April 10, 2019

**Re: The Cellar Restaurant**  
**1025 Iomas Blvd. Albuquerque NM 87102**  
**Traffic Circulation Layout**  
Engineer's/Architect's Stamp **04-05-2019** (J13D075)

Based upon the information provided in your submittal received 04-08-2019, the above referenced plan cannot be approved for Building Permit until the following comments are addressed:

1 TCL PLAN  
1/8" = 1'-0"

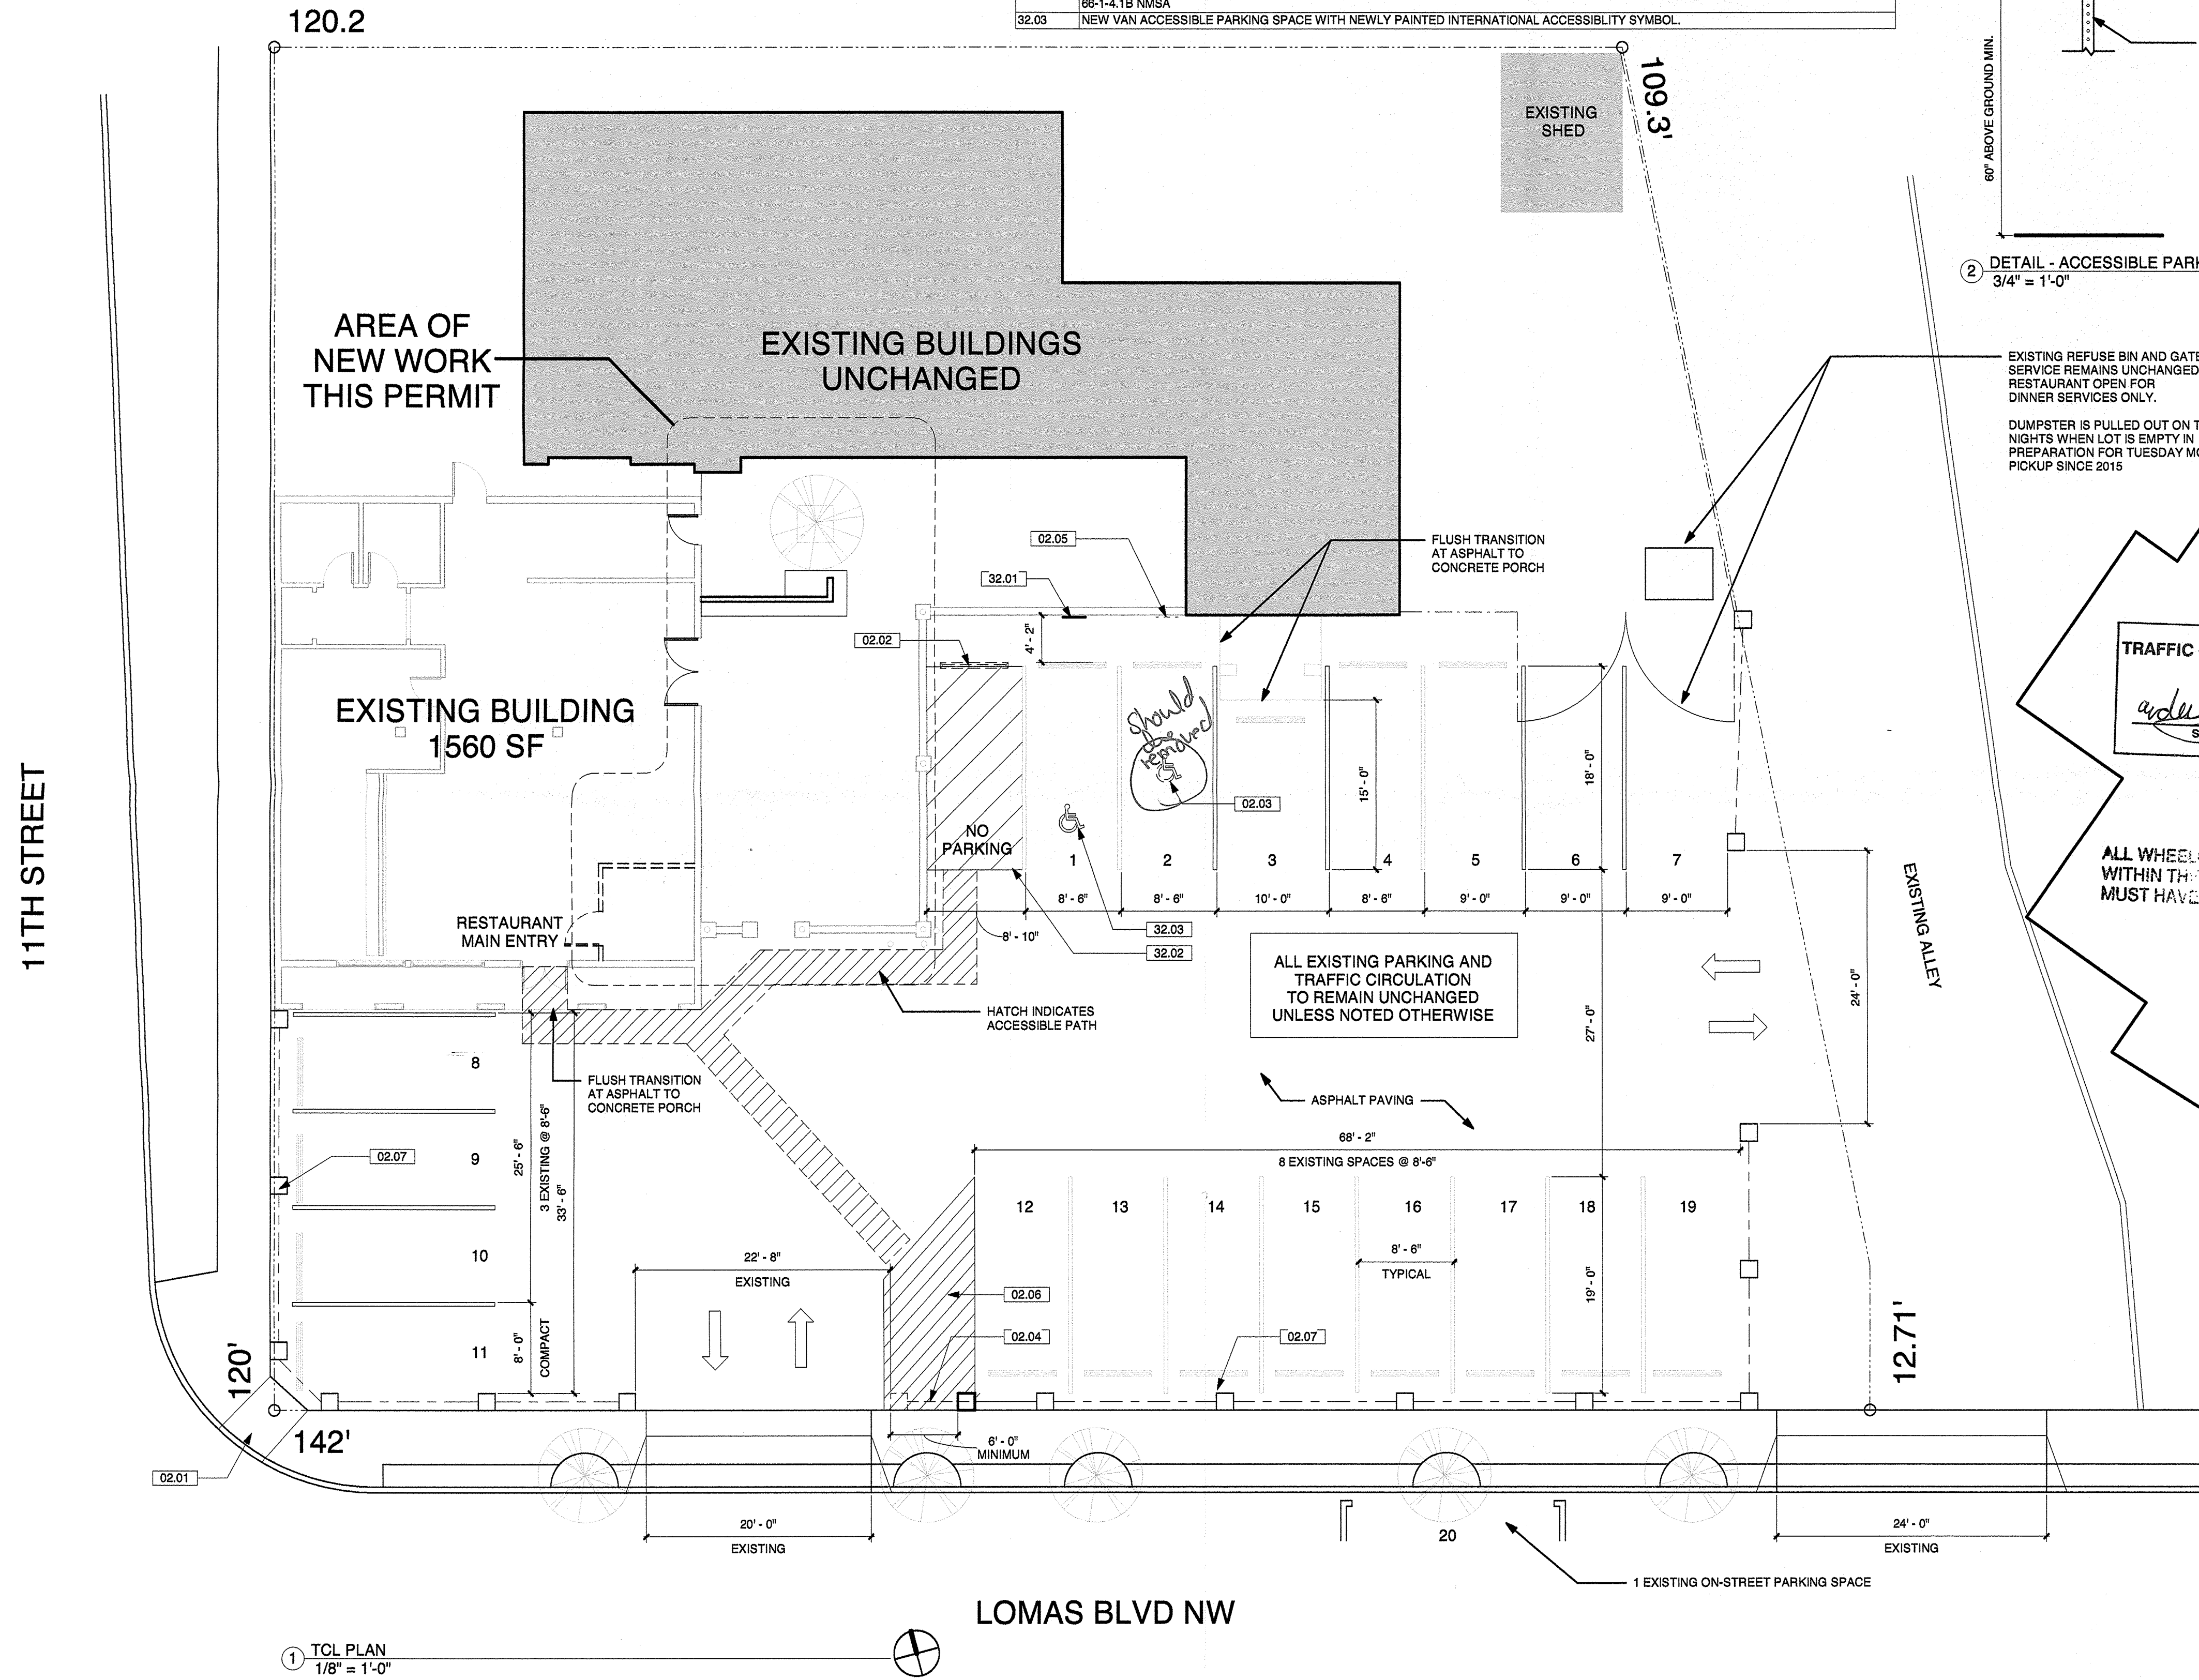
1. The ADA accessible parking sign must have the required language per 66-7-352.4C NMSA 1978 **"Violators Are Subject to a Fine and/or Towing."** Please call out detail and location of HC signs.

2. The ADA access aisles shall have the words **"NO PARKING"** in capital letters, each of which shall be at least one foot high and at least two inches wide, placed at the rear of the parking space so as to be close to where an adjacent vehicle's rear tire would be placed. (66-1-4.1.B NMSA 1978)

3. ADA curb ramps must be updated to current standards and have truncated domes installed.
4. A 5 ft. keyway is required for dead-end parking aisles.
5. Per IDO, a 6 ft. wide ADA accessible pedestrian pathway is required from the public sidewalk to the building entrances. Please clearly show this pathway and provide details.

6. Per DPM, a 6 ft. wide ADA accessible pedestrian pathway is required from the HC parking stall access aisles to the building entrances. Please clearly show this pathway and provide details.

7. ADA accessible pedestrian pathway **should not be placed behind parking space** or adjacent to a vehicular way. Vehicle and pedestrian/wheel chair conflicts should be avoided as much as possible.

8. Please include a copy of your shared access agreement with the adjacent property owner. The existing alley doesn't seem to be a public alley.
9. Please remove all the clouds and add keyed notes instead.
